Please ask for Mr G Hynds
Our Ref GH/S746/04
Your Ref EG/22/15/PL

S.746 EASTERGATE UV & TURBIDITY MITIGATION SCHEME – APPLICATION FOR REMOVAL OR VARIATION OF A CONDITION FOLLOWING GRANT OF PLANNING PERMISSION

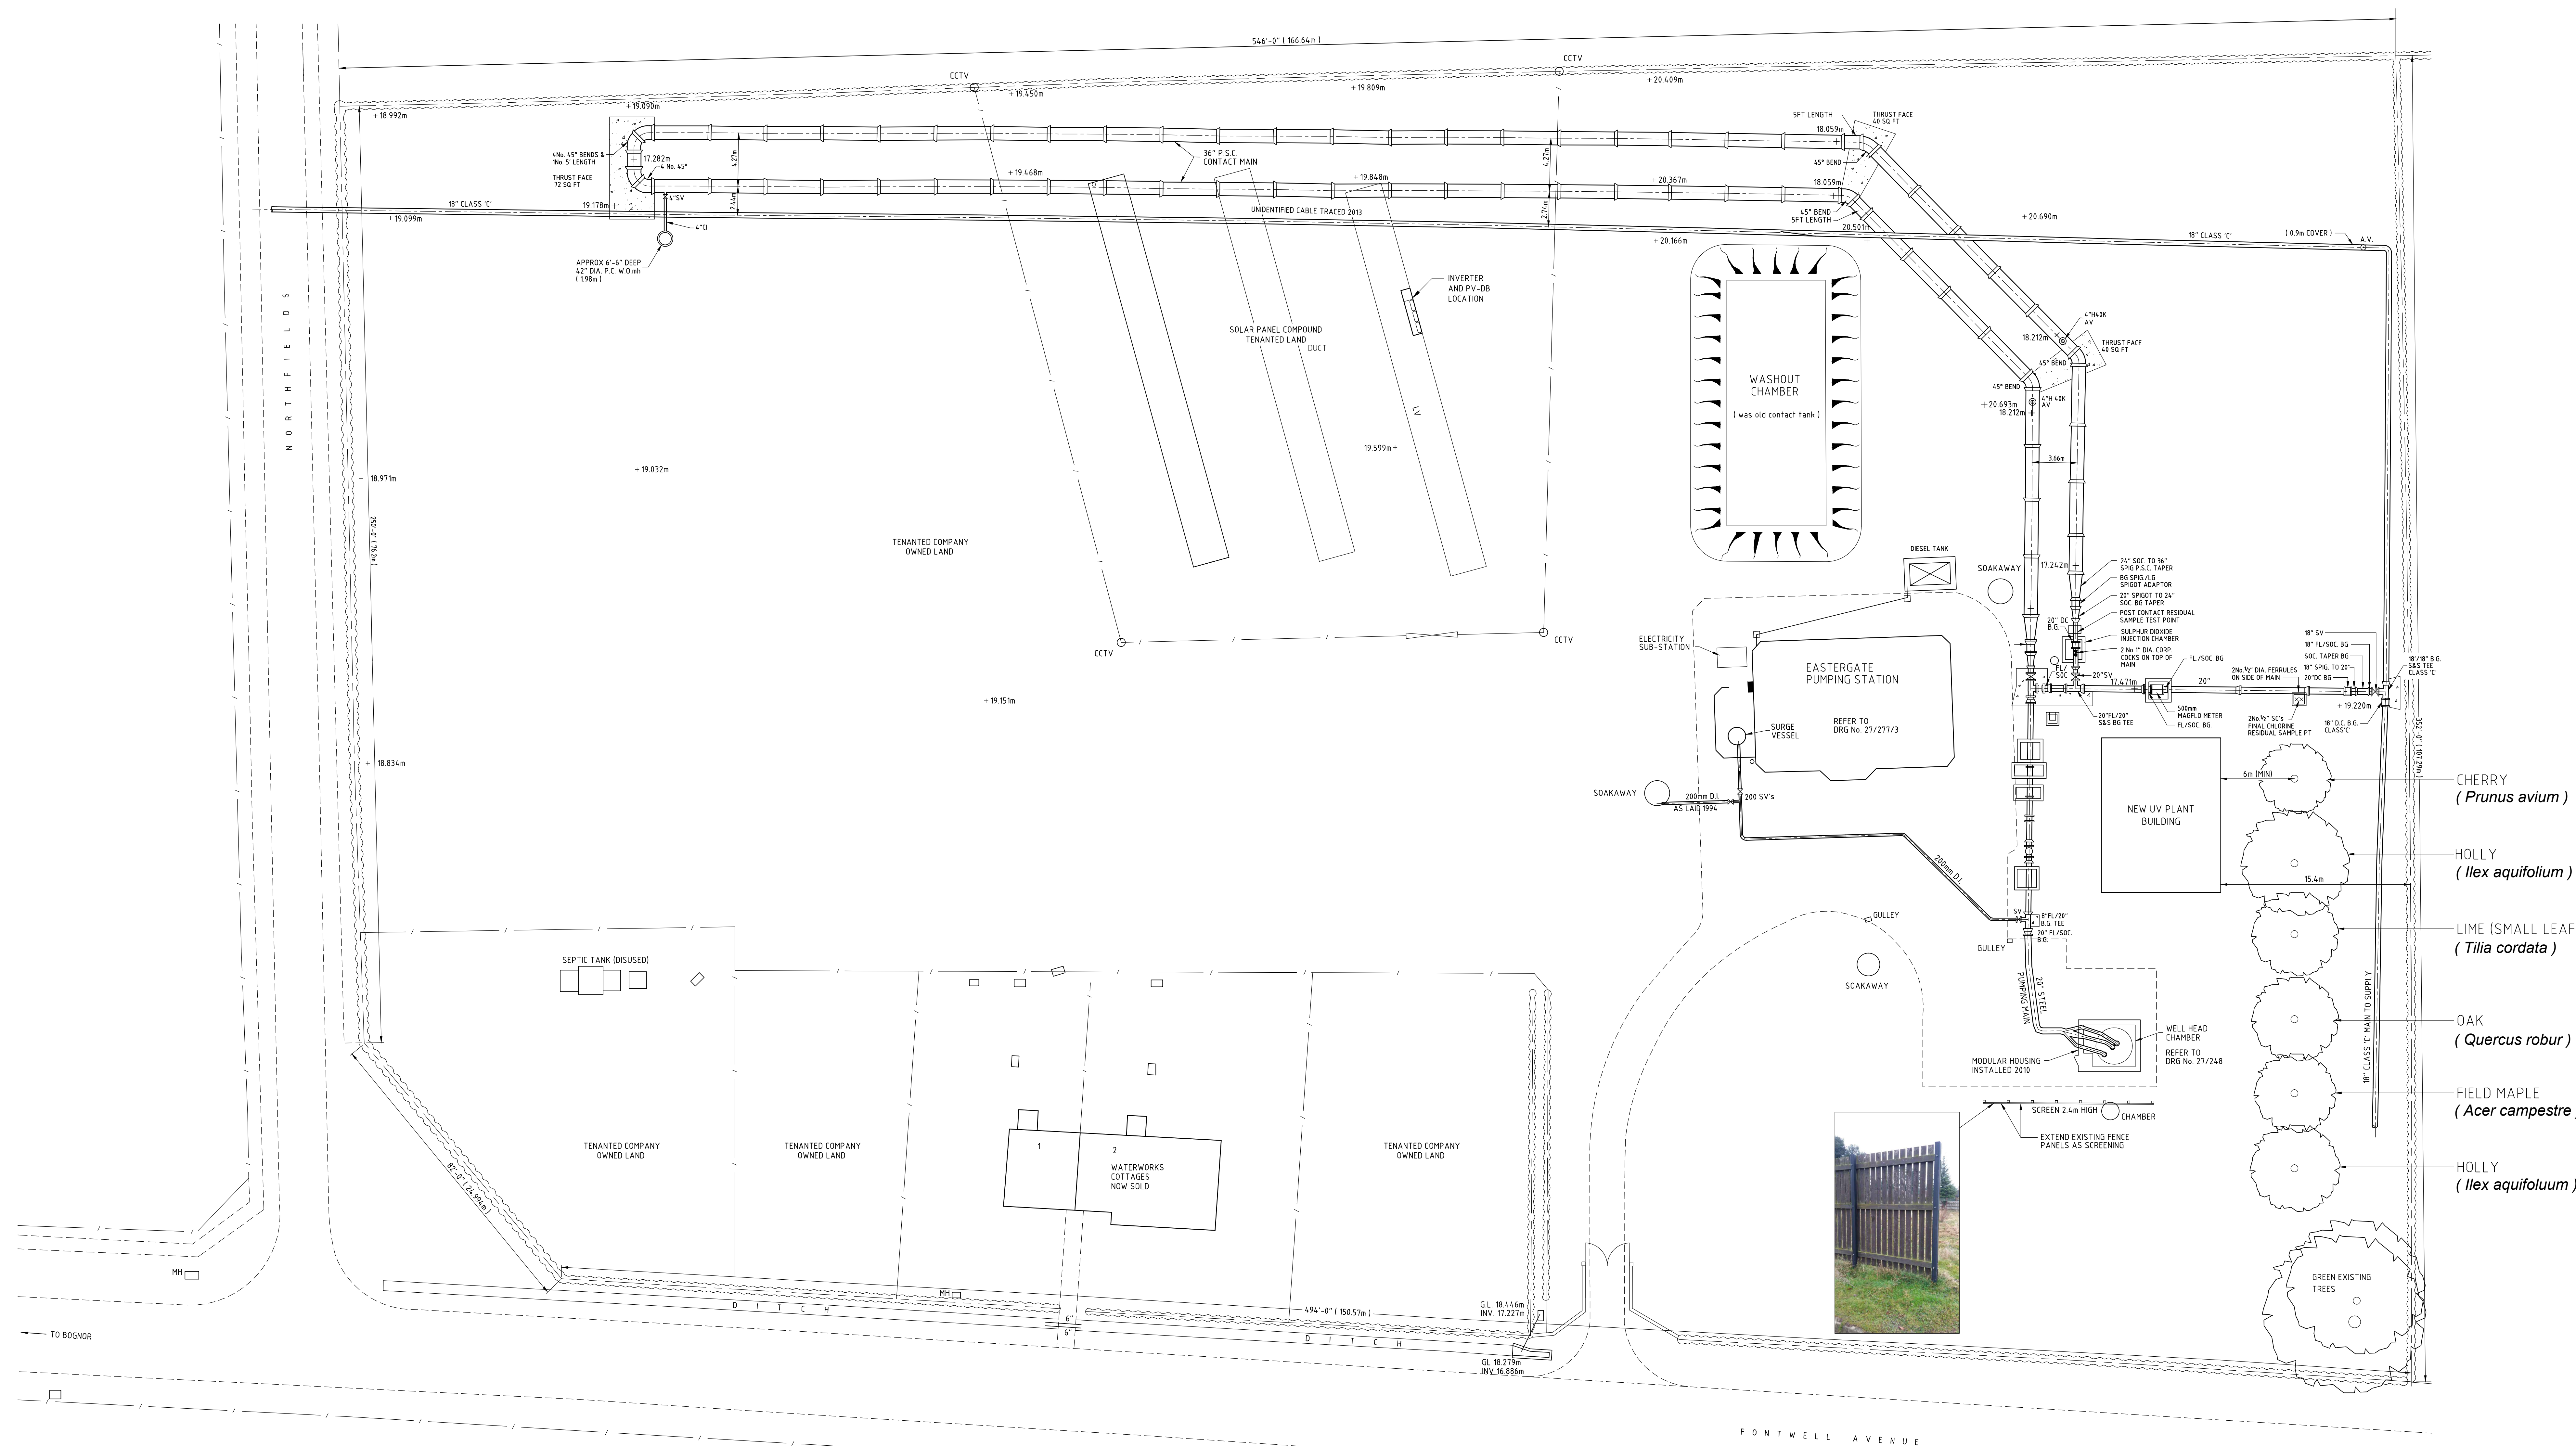
In addition please find enclosed our drawing 27/307 titled 'Eastergate Water Treatment Works – Proposed Landscape Details'. To assist with future screening of the building we have proposed the layout as indicated for your consideration.
